Your ref: SSD-40138508

Subject: Baldon Wind Farm (SSD-40138508) – Environmental Impact Statement

Adam Vey
04 October 2024
Director South West
Biodiversity, Conservation and Science Group
NSW Department of Climate Change, Energy, the Environment and Water

ATTACHMENT A – BCS Assessment Summary for Baldon Wind Farm Environmental Impact Statement (SSD-40138508)

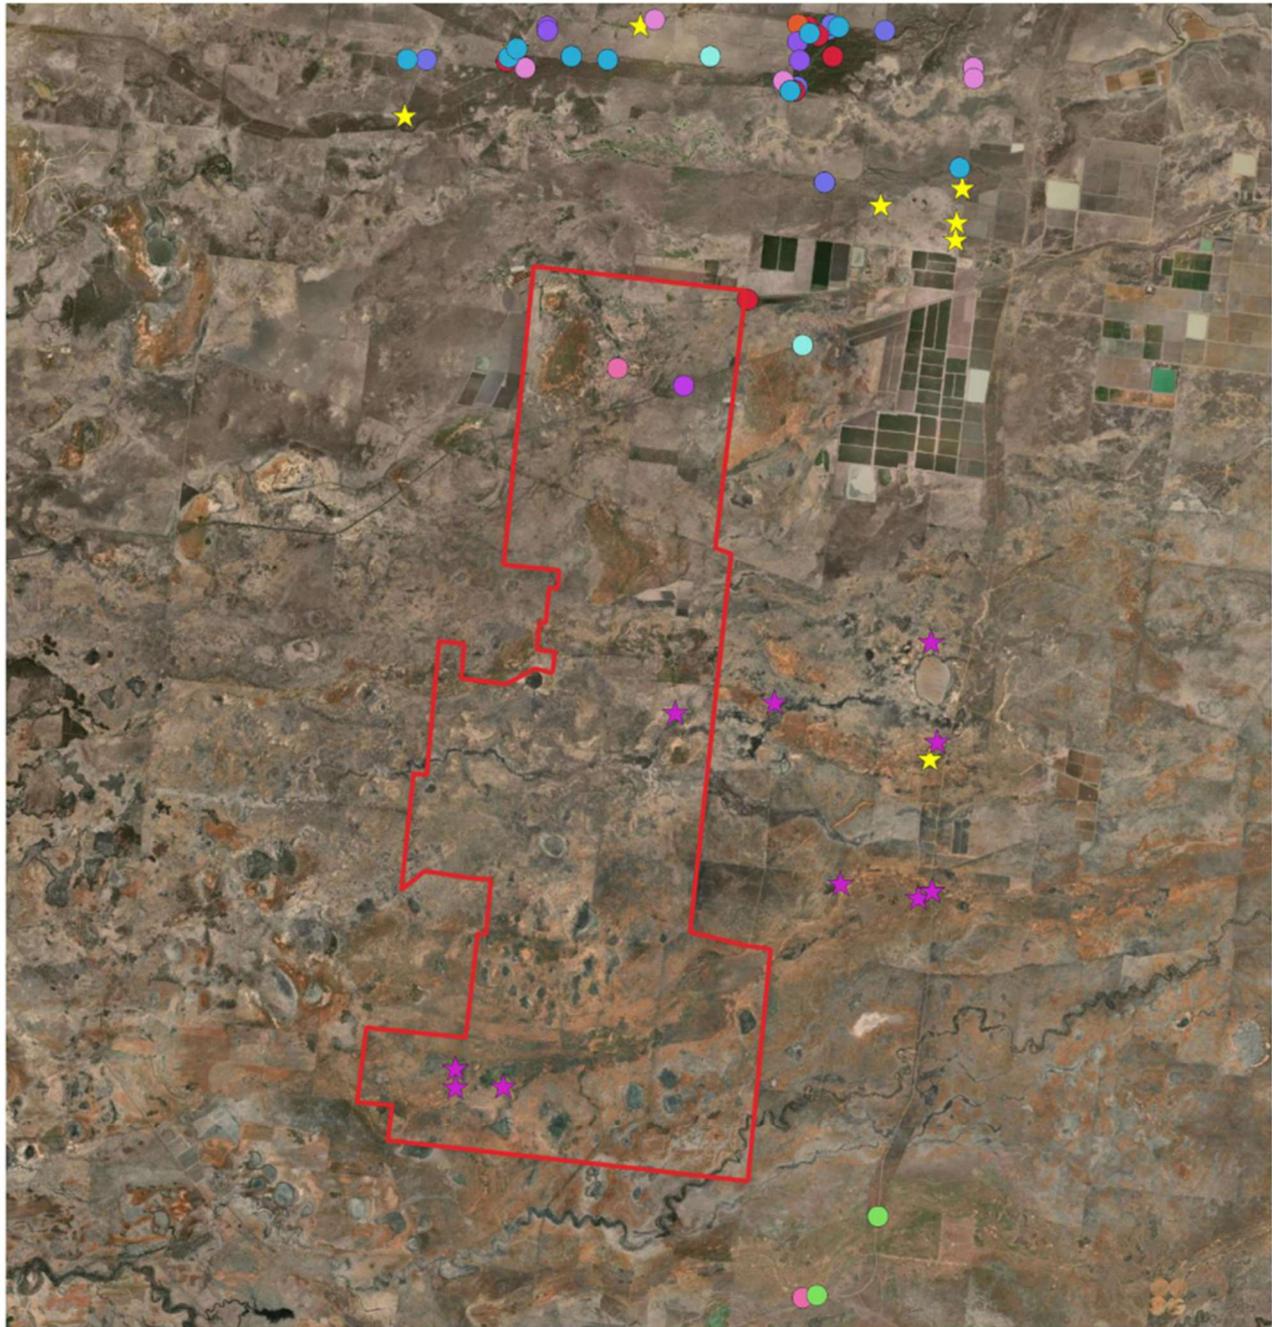
- 4.1. Update section 7 of the BDAR to specifically detail of how impacts to biodiversity have been avoided, including a table showing the impacts on biodiversity and how impacts have been avoided/reduced throughout the assessment process.
- 4.2. Update Figure 7-1 to map biodiversity values.
- 4.3. Update section 7.1.2 to discuss how the chosen wind turbine generators will avoid or minimise impacts on biodiversity values, and why these turbines were chosen over others.
- 4.4. Explore options to avoid and minimise impacts to biodiversity and document them in the BDAR.
